District ref: 6/2017/2667/FULL

HCC ref: WH/290/2017

58 Plough Hill

Erection of a detached 4-bedroom house following demolition of existing

Proposed Site Plan 1:200

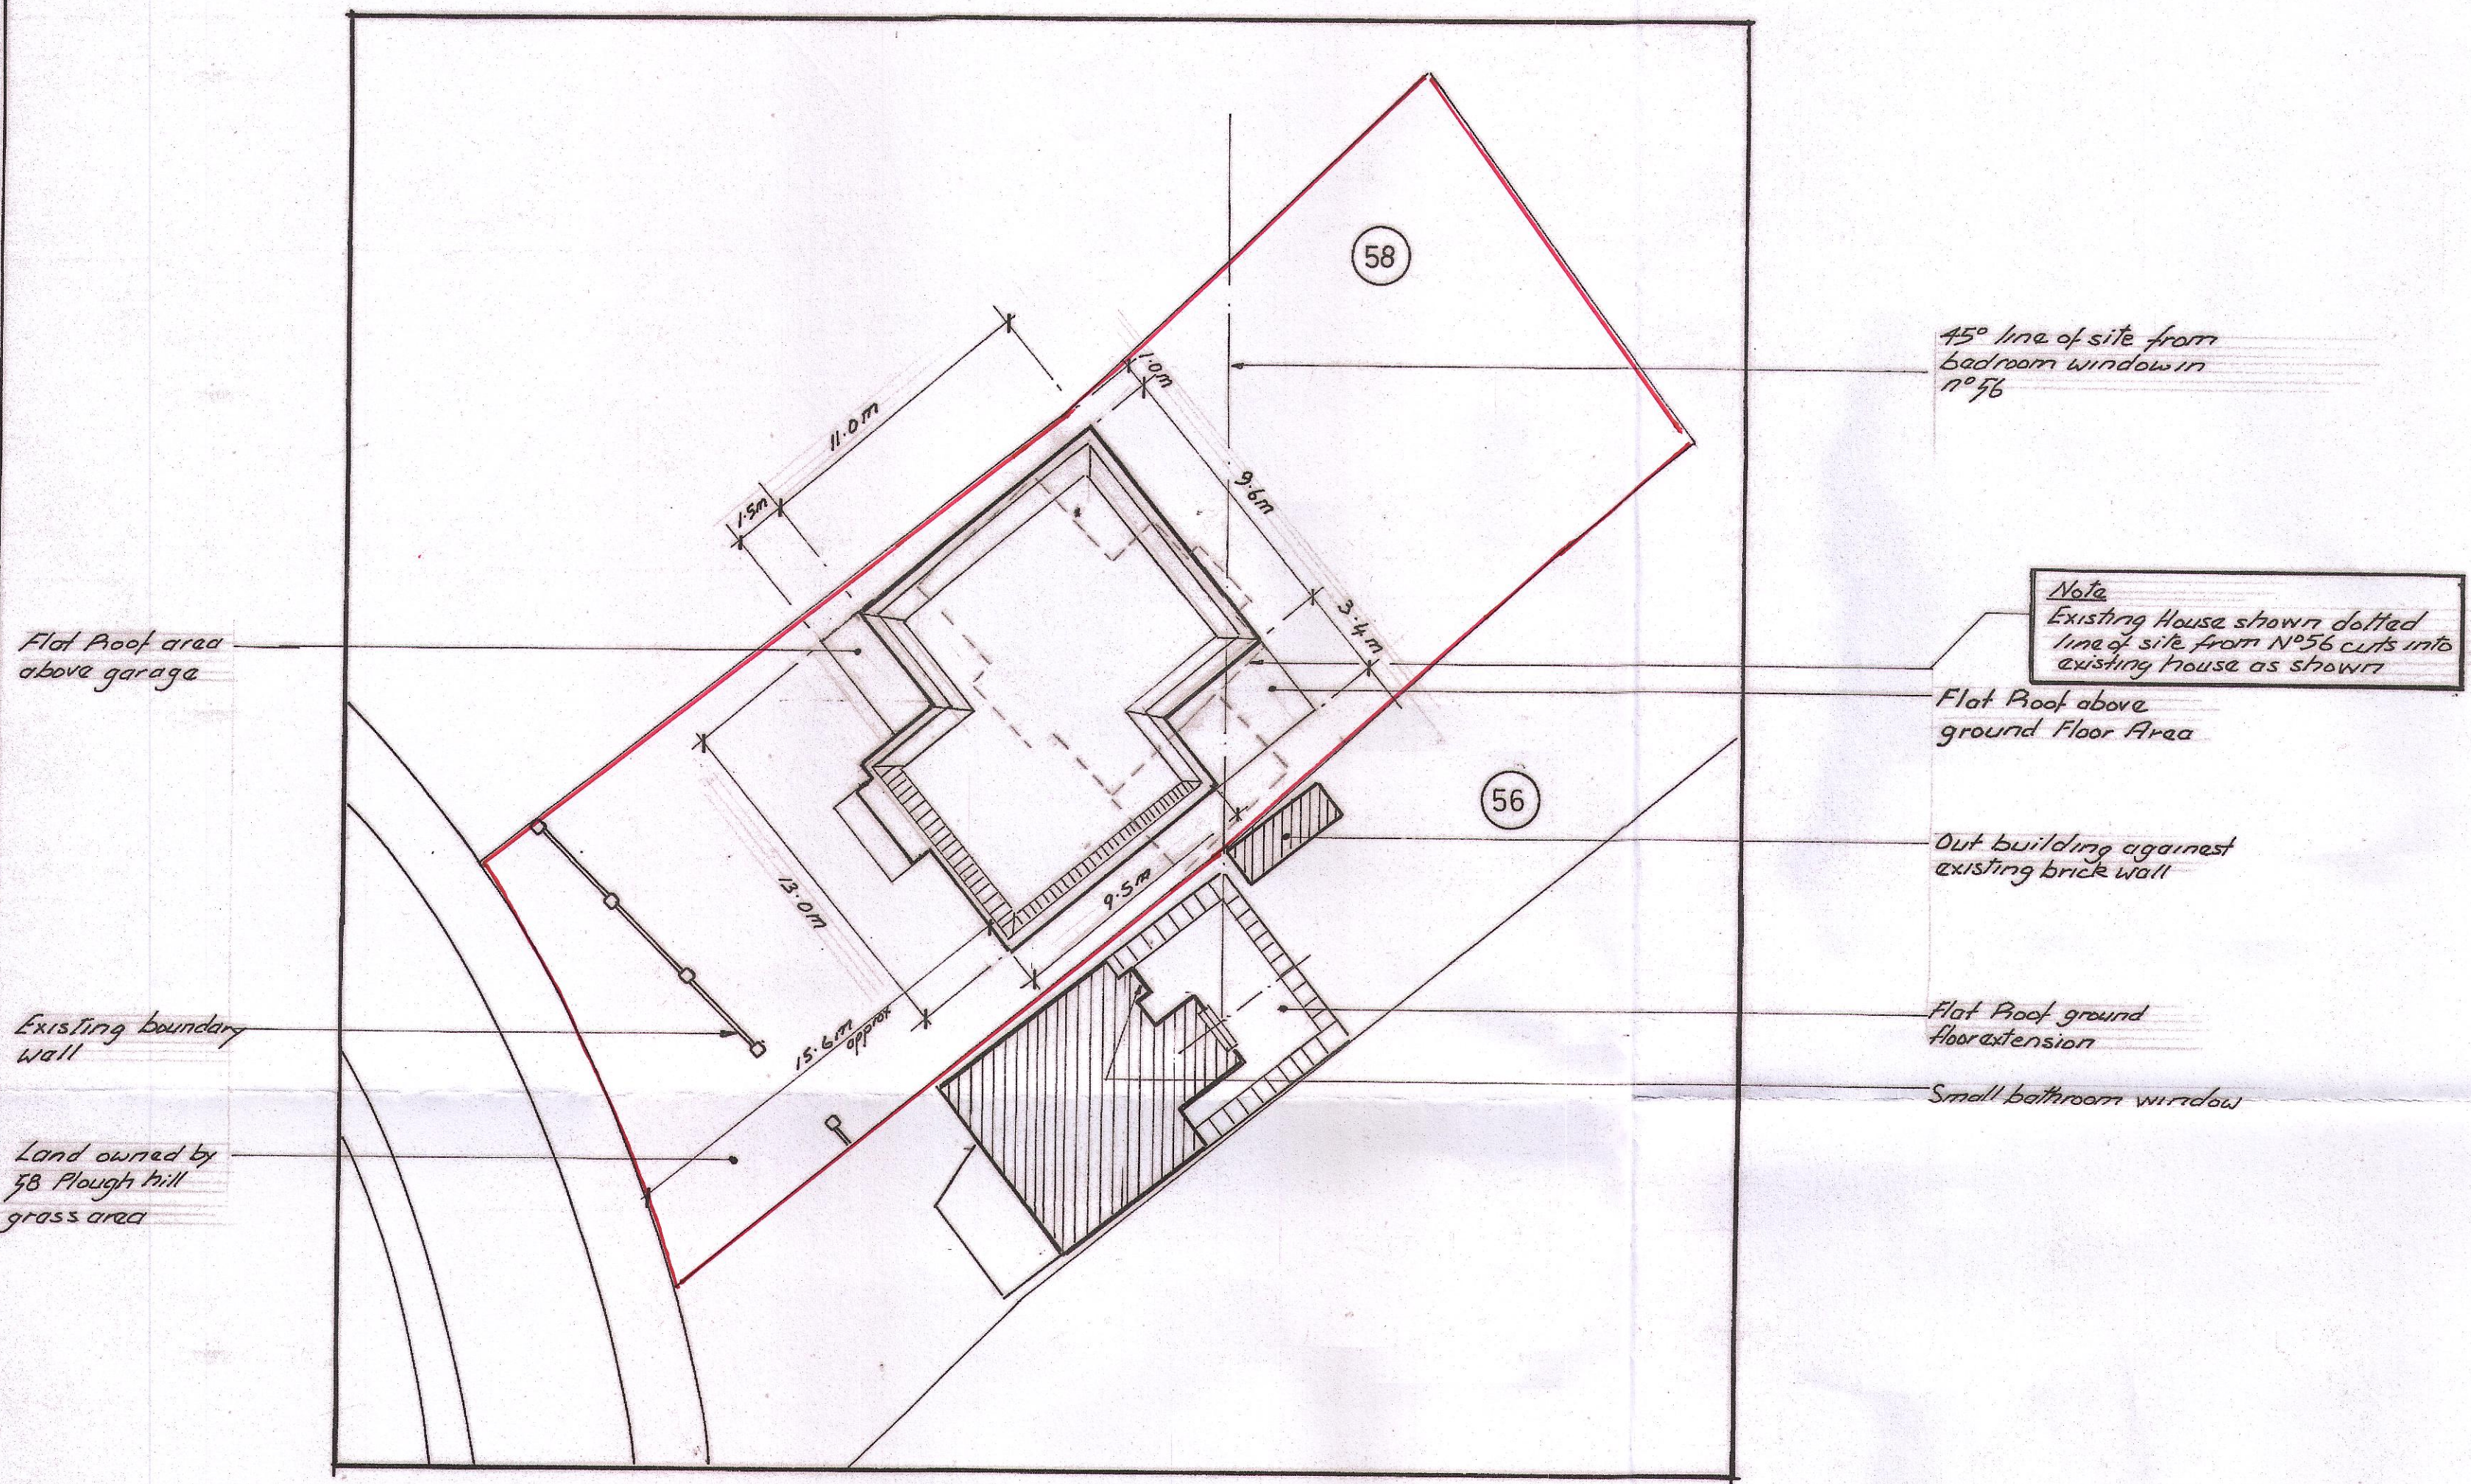
For the proposed site on Hill Rise, the access is located close to the B157 junction, however to revised VXO is an improvement to the distance from the junction. There are no accidents on our records reported in the previous five years relating to the site or associated access. Visibility is acceptable and the development is unlikely to impact upon highway user intervisibility. As such, the revised access is unlikely to increase any safety concerns with the existing vehicular access.

The sites parking area is of useable dimensions including the garage which meets the advised 3x6 meter dimension. The LPA may review the total parking provision at the site, however for the Highway Authority the design and layout of internal access arrangements are acceptable.

The application form proposes works to the public highway are required to form a new access, however this is not apparent on the provided plans, with no discernible change between existing and proposed, as such this comment is made on the understanding that no works are required.
